# Aldington & Mersham Support Group

## Supplemental Questions and areas of further clarification

In summary we set out below firstly what we believe are relevant "supplemental questions" on which we hope the Exa might consider seeking clarification and answers from the Applicant and relevant Statutory Consultees. Secondly, as indicated we think there are other specific subject areas which require further clarification.

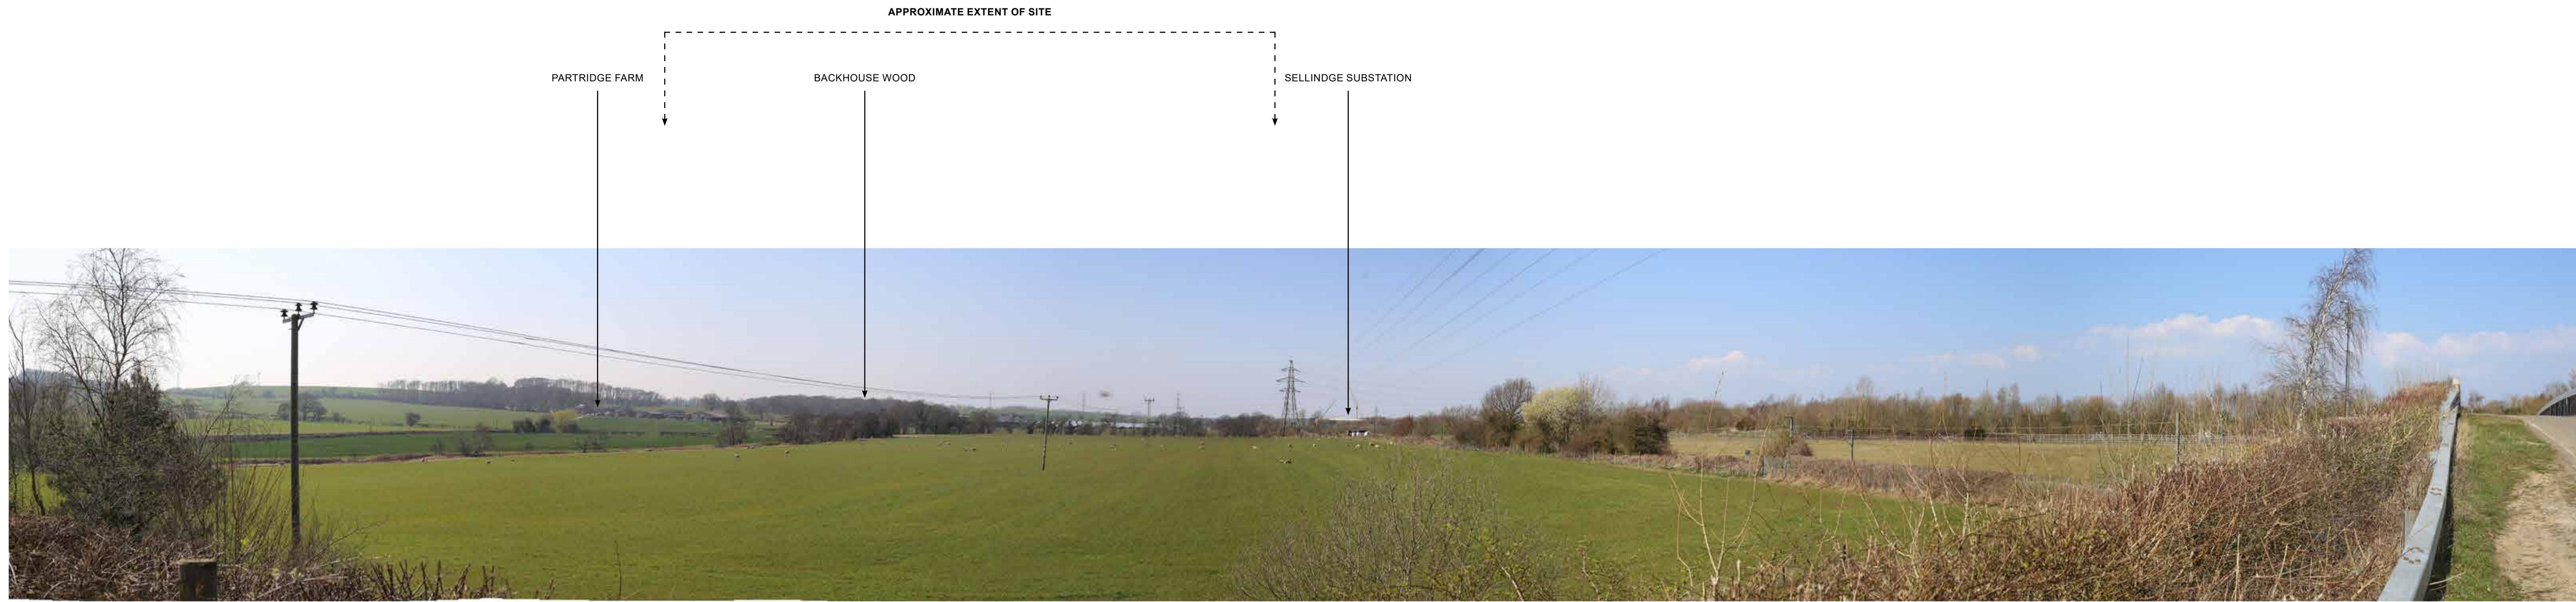
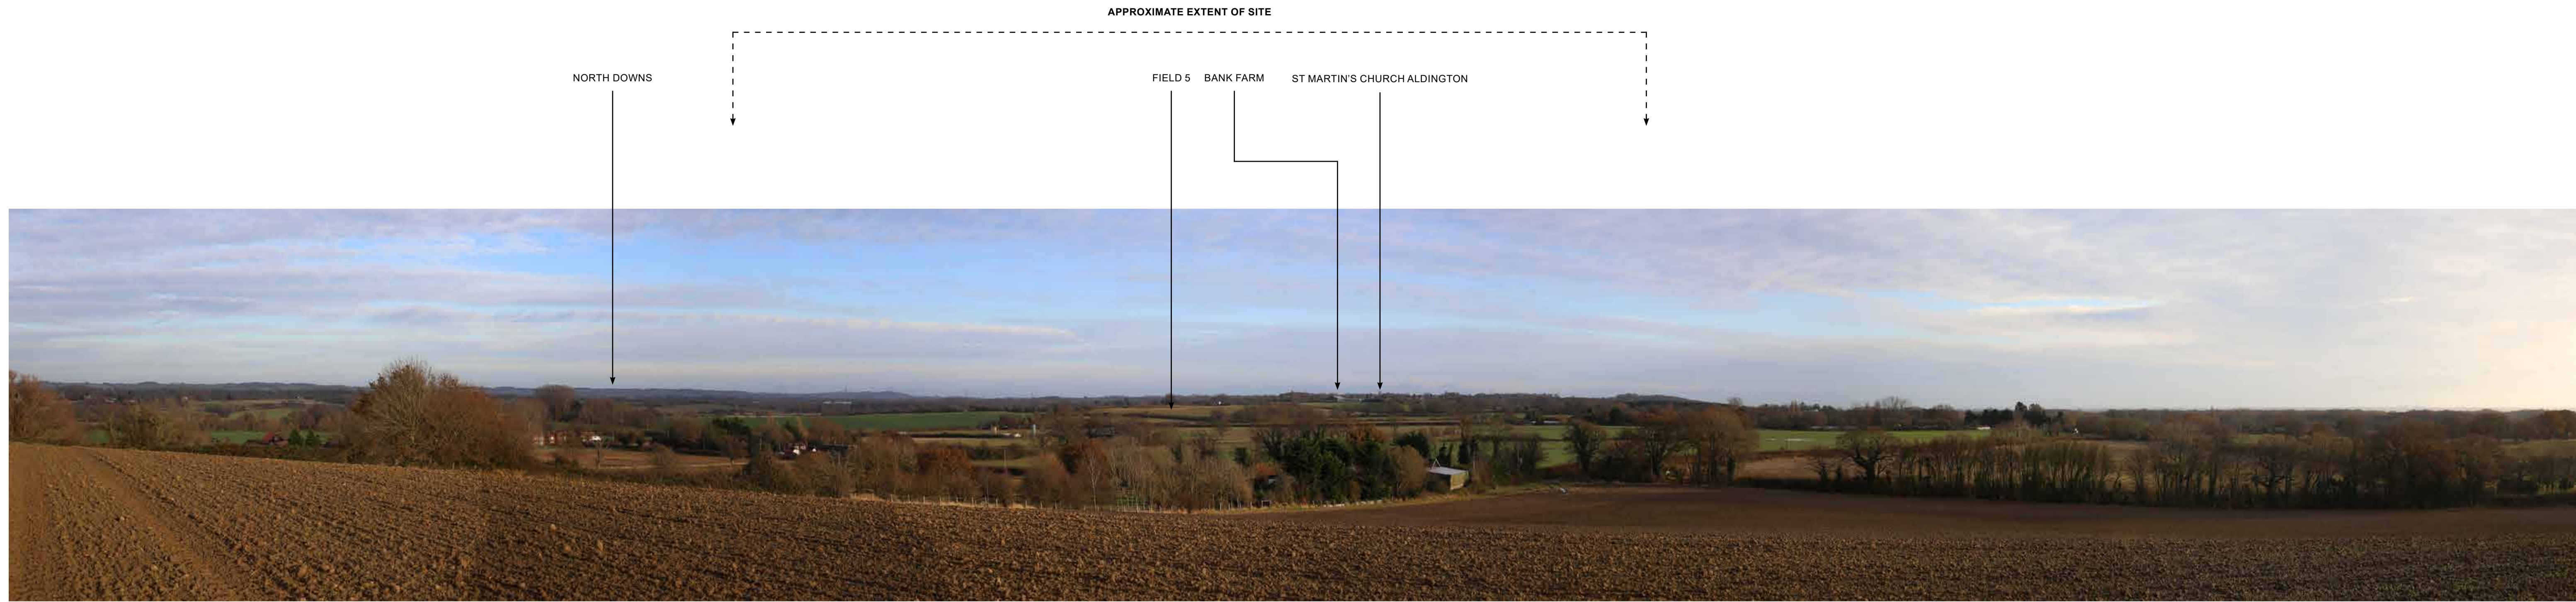
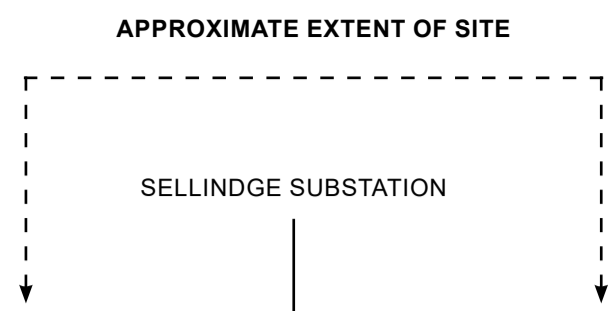
- We maintain that the Applicant's repeated failure to provide representative photomontages of the completed development from various viewpoints is no accident. Can it explain why it failed to do this?

- Further, even at this late stage in the process the photomontages produced are of an inadequate resolution.
- We ask that the Exa questions the Applicant on this issue and asks it to identify on the photographs presented, the BESS and inverter enclosures and the water tanks. We cannot see them and do not believe they have been included in the dataset.
